Ribble Valley Borough Council  
Housing & Development Control

Application no: **3/2019/0569**

Address: **Foxfields Farm, Whalley Road, Hurst Green, BB7 9PN**

Proposal: **Erection of single-storey events/function building. Extension of service road and grass over hardstanding area currently used as a base for a marquee**

DRAWING TITLE
EXISTING & PROPOSED SITE PLANS

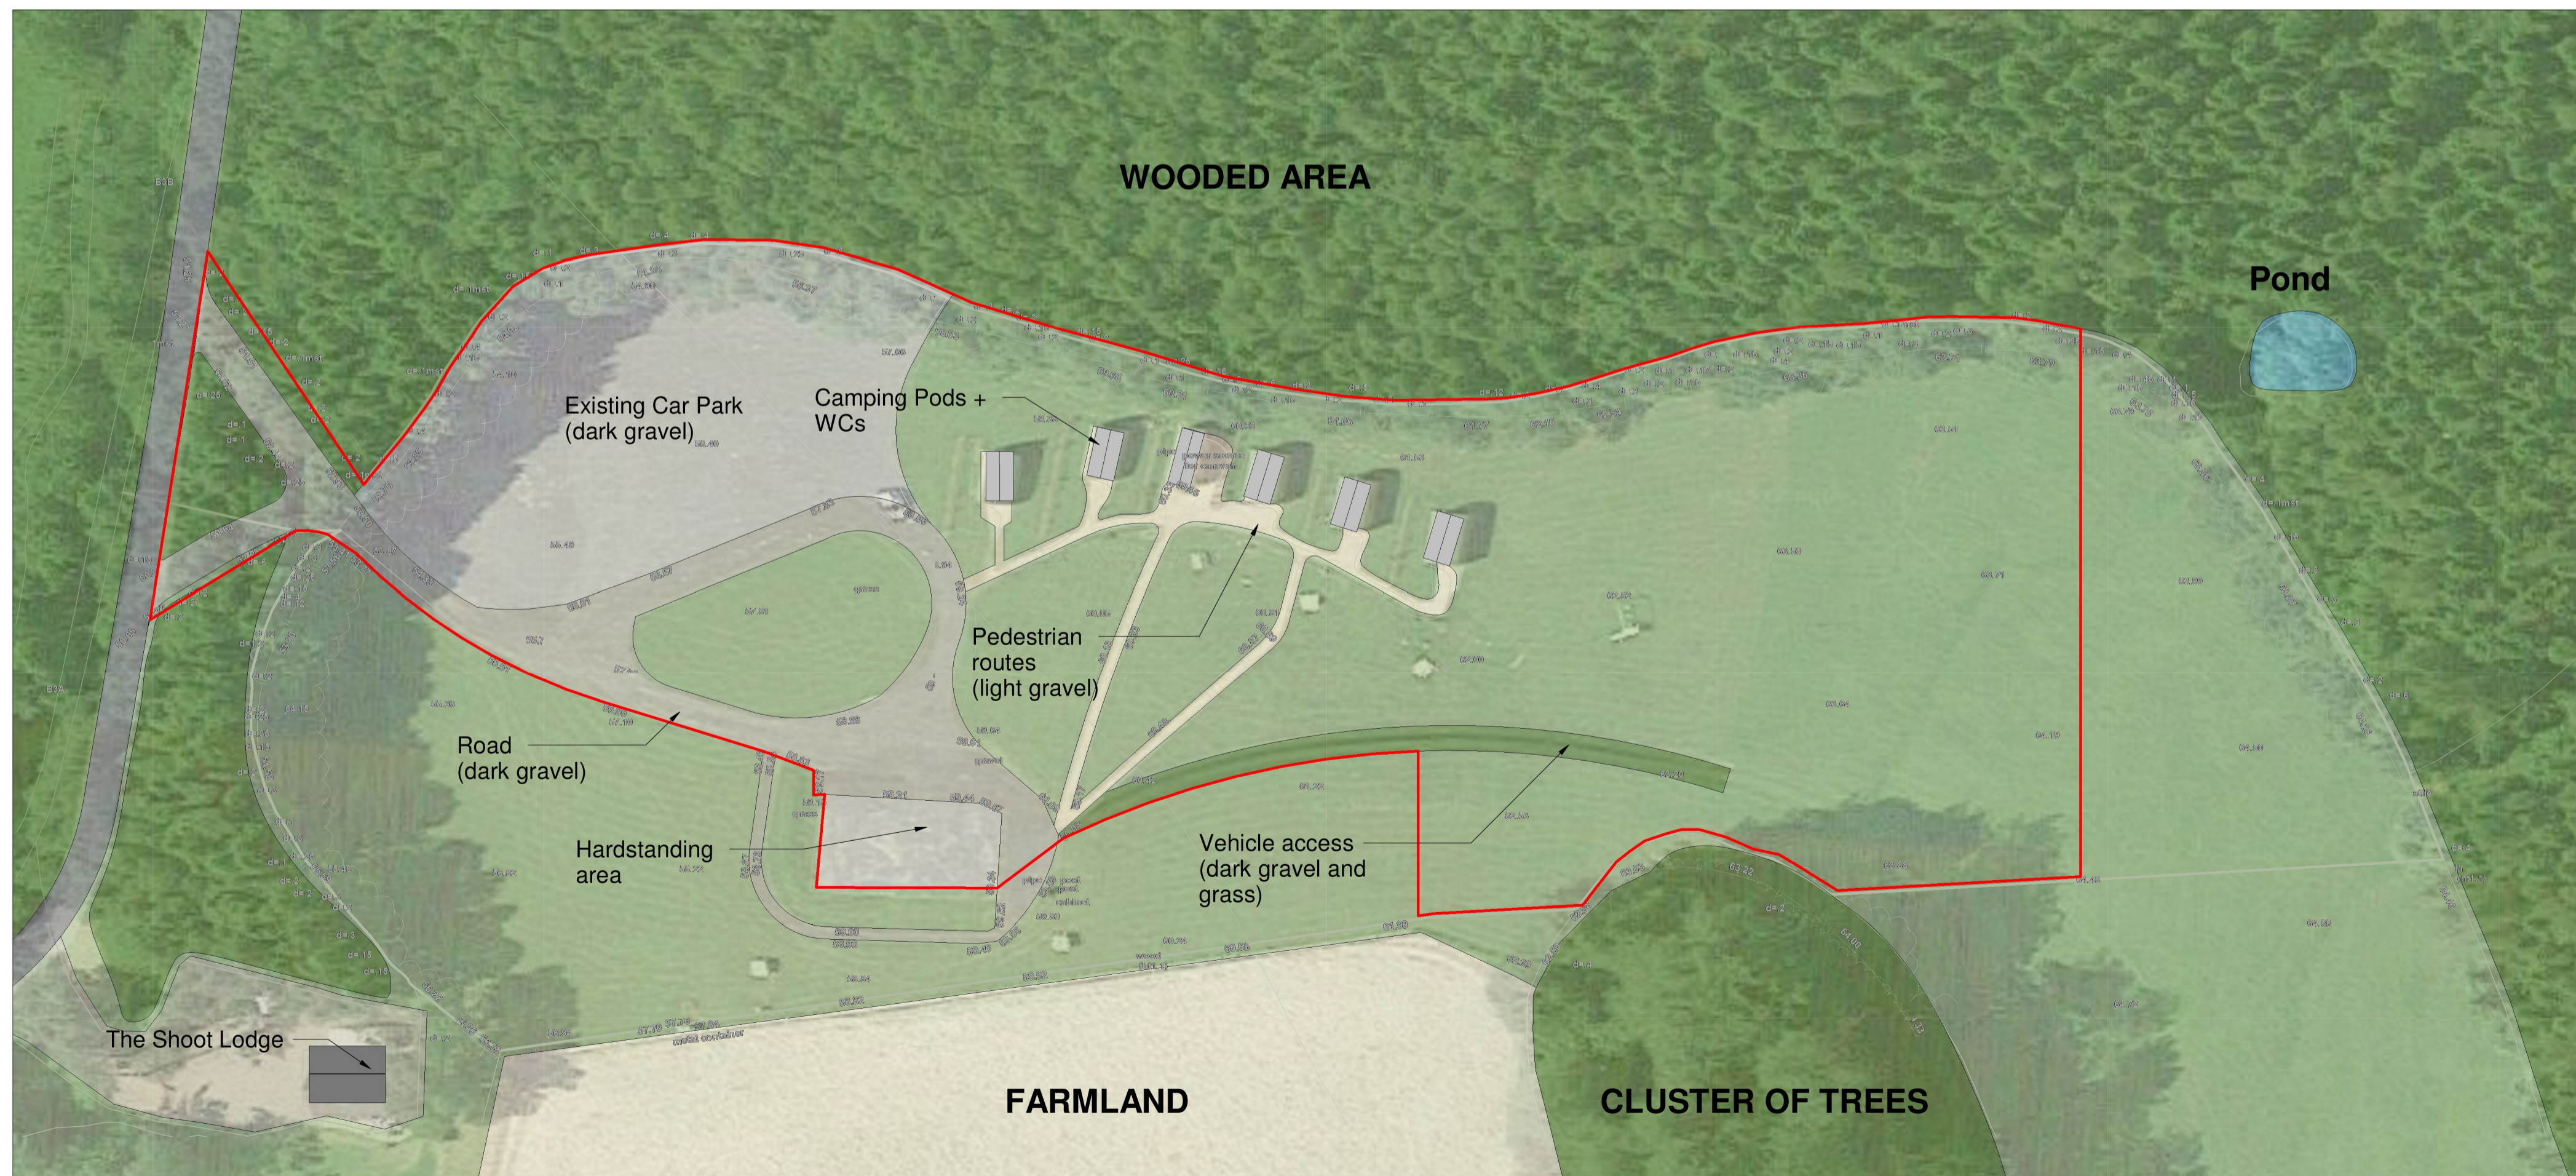
Access to the proposed events/function building will be via an existing access point on Whalley Road, which is a classified Road namely B6243 and is also subject to the national speed limit.

Therefore, with no additional requirement for any overflow parking, the Local Highway Authority would consider 70 parking spaces to be sufficient for the proposal.

The requirement for a swept path analysis to be undertaken at the application site to ensure the safe manoeuvrability of coaches and articulated Lorries to be associated with the proposal has been carried out and is also considered to be sufficient for the proposal

Although It must be reiterated that, if planning permission is granted for the events/function building, being of a permanent structure with increased business potential. Then the approved parking provision shall remain the same in perpetuity of the development and therefore if a further 28 functions are also permitted per year for marquees / tepees i.e. of a temporary structure, alongside the proposed permanent structure which would then coincide with the above proposed planning application for a permanent events/function building, then ultimately the application site would generate a higher provision for parking than the 70 existing parking space as documented within the submitted application form and would as a result lead to an overall intensification of use at the application site.
